Application by Elements Green Trent Limited: Great North Road Solar and Biodiversity Park (Application Reference: EN010162)

Submissions at Deadline 2

Appendix 1 of this letter provides an overview of the documents submitted by the Applicant at this Deadline. Table 1 comprises the application documents for which updated versions are being submitted and summarises how and why the document has been updated.

NOTES
1. ALL DIMENSIONS ARE IN METRES UNLESS STATED OTHERWISE.

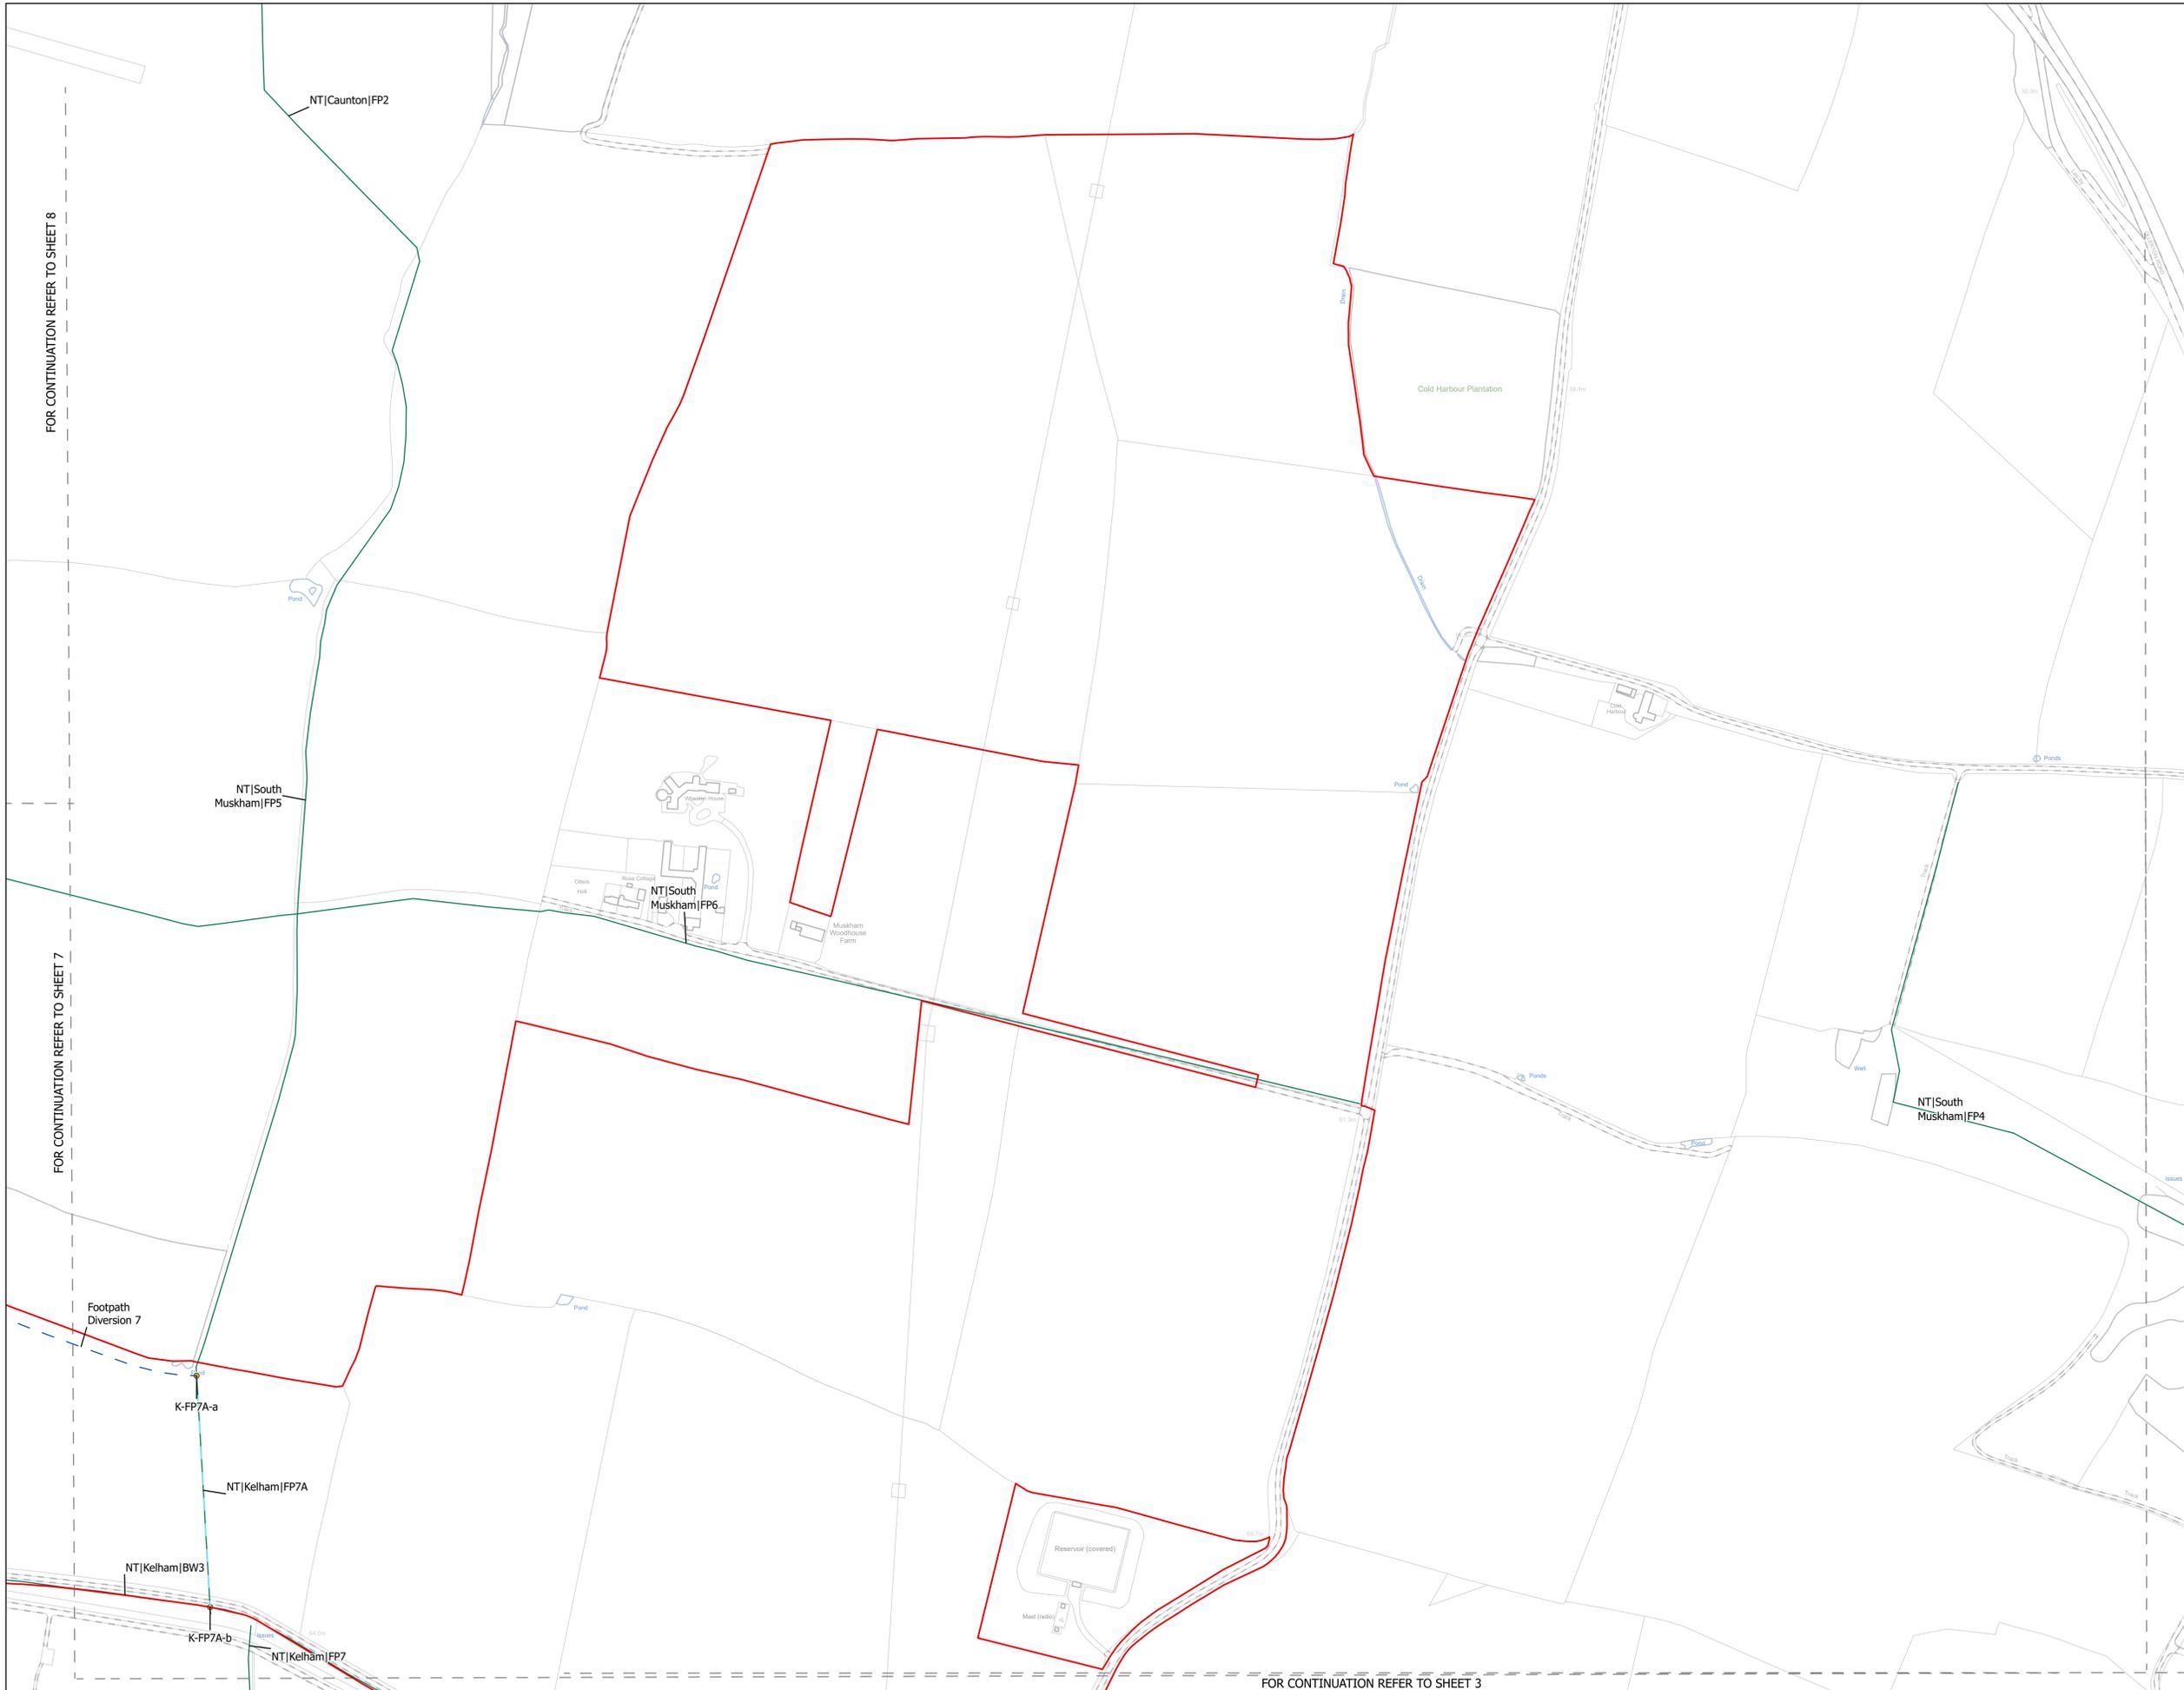
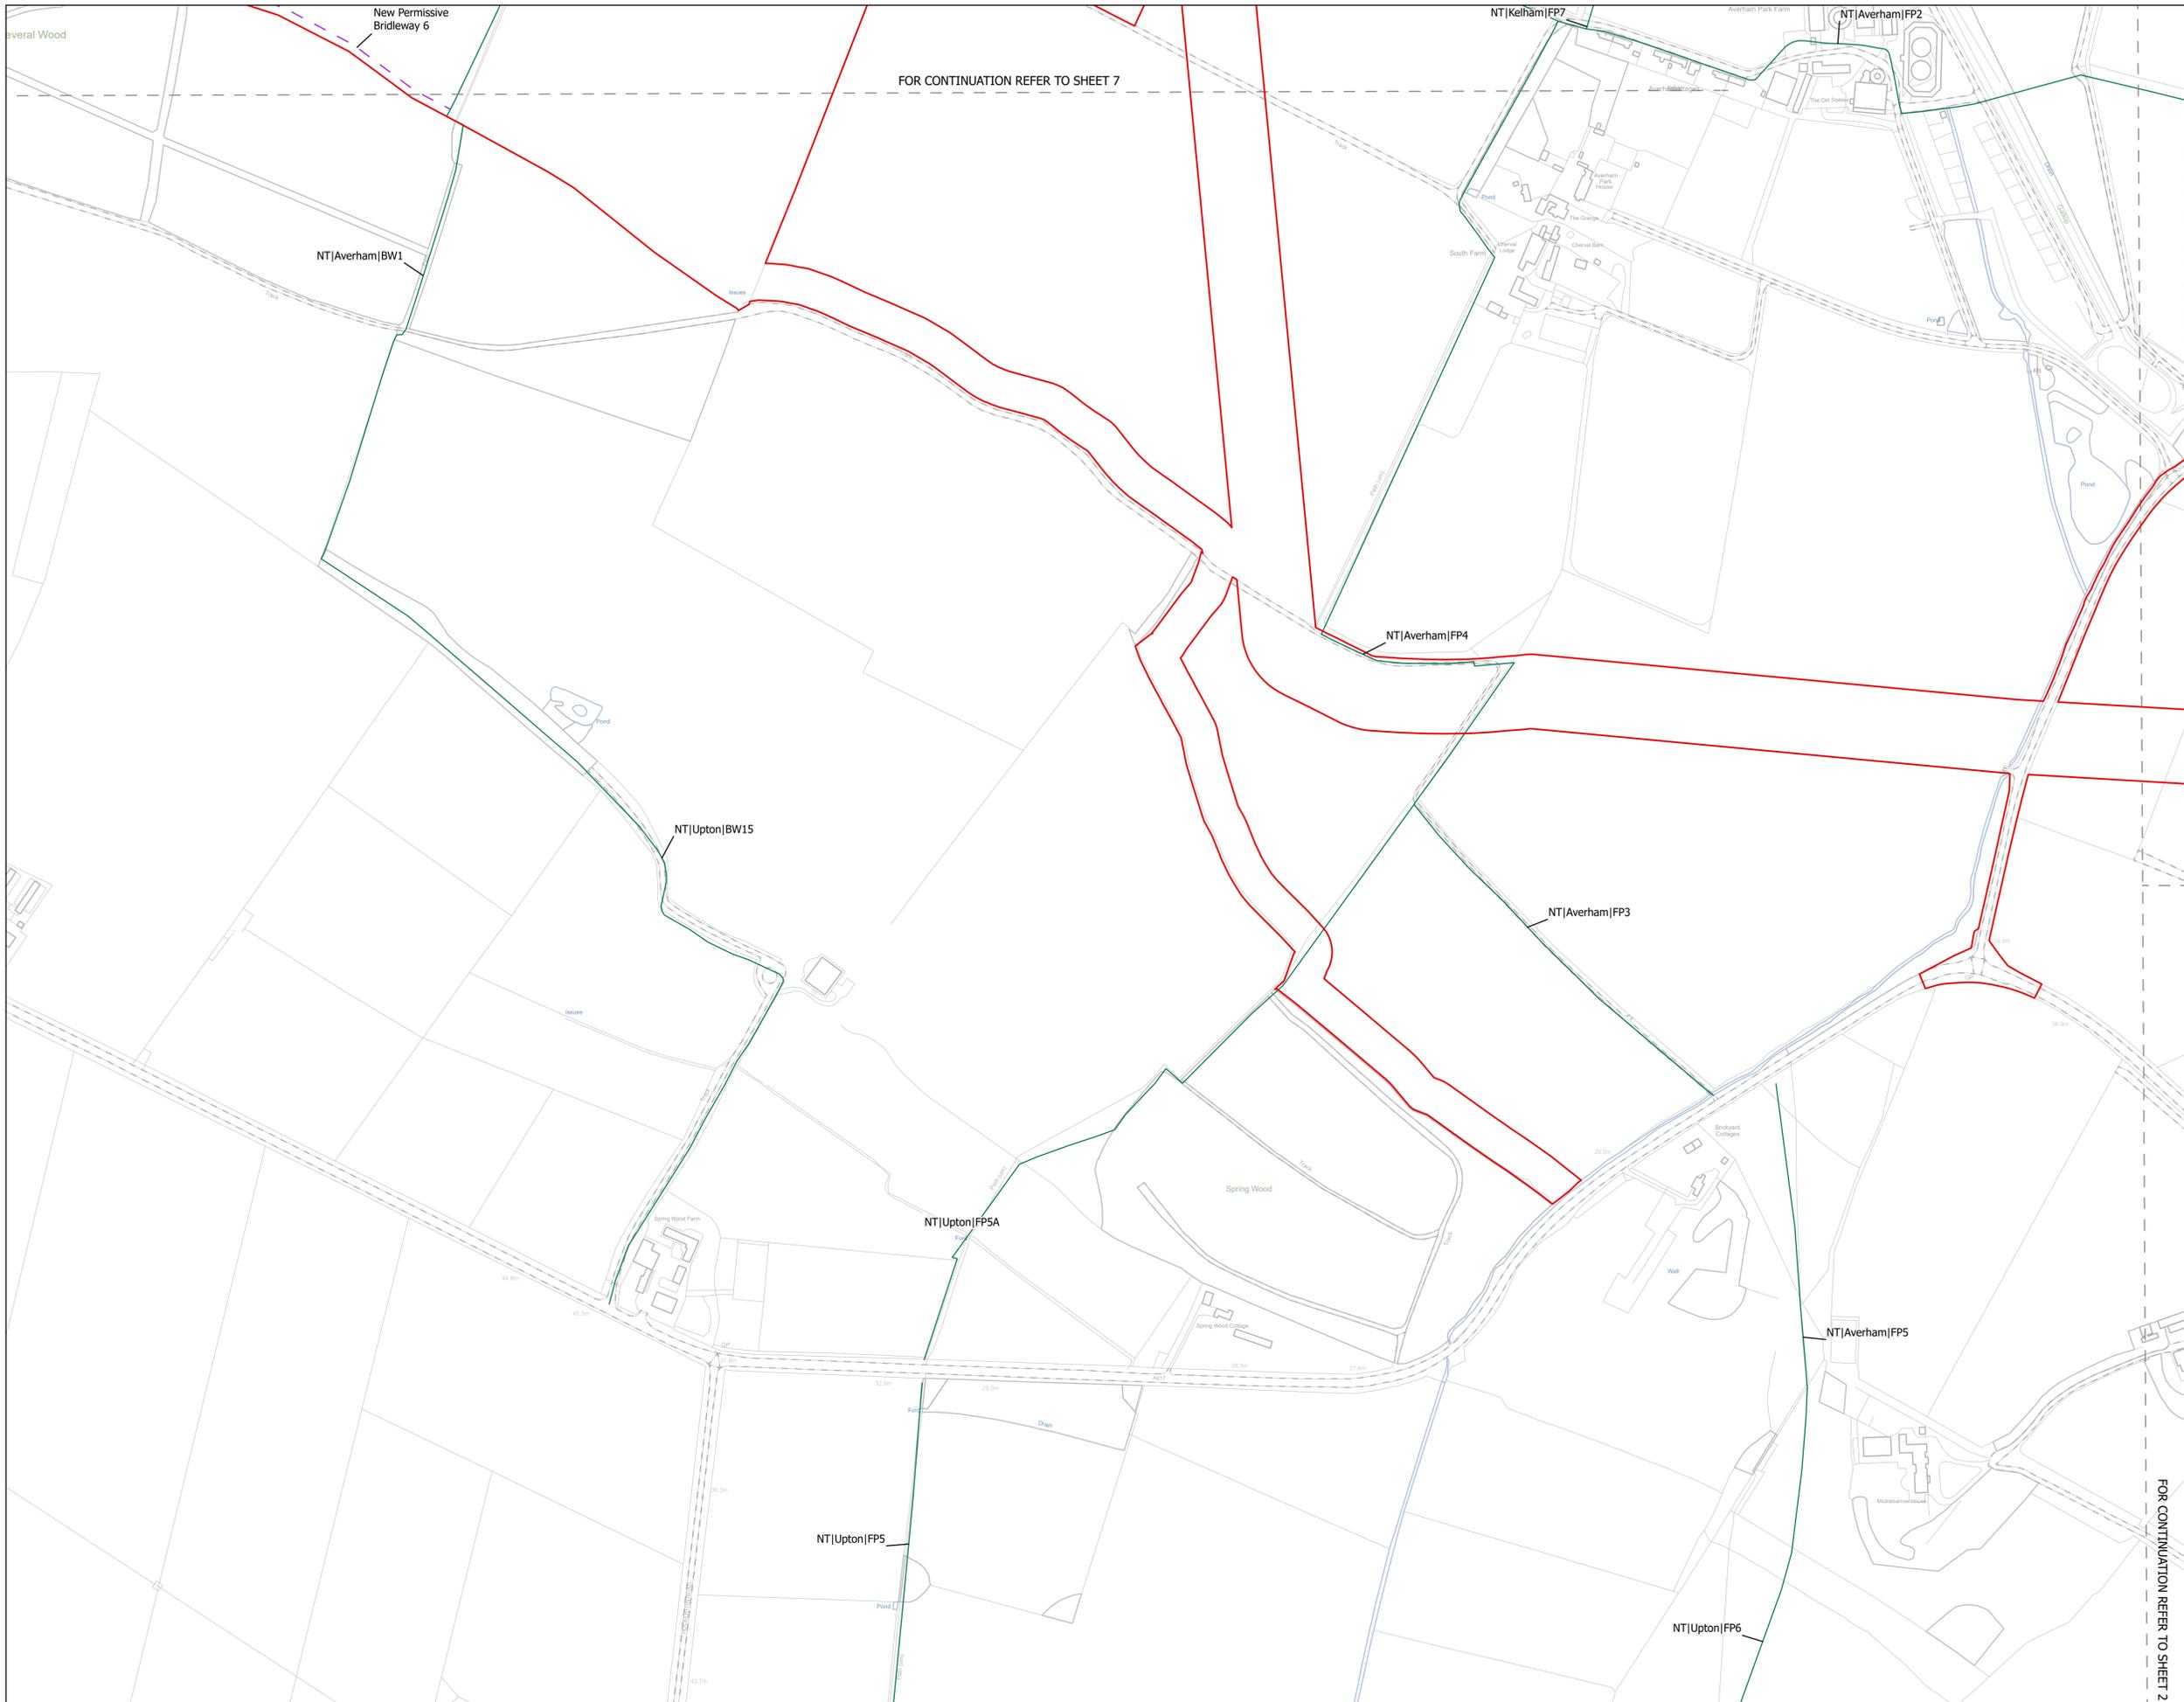
2.4A	2	Public Rights of Way Diversions and Permissive Routes Plan	Updated Figure to remove part of Permissive Bridleway along Bridleway Diversion for Construction and Decommissioning only route
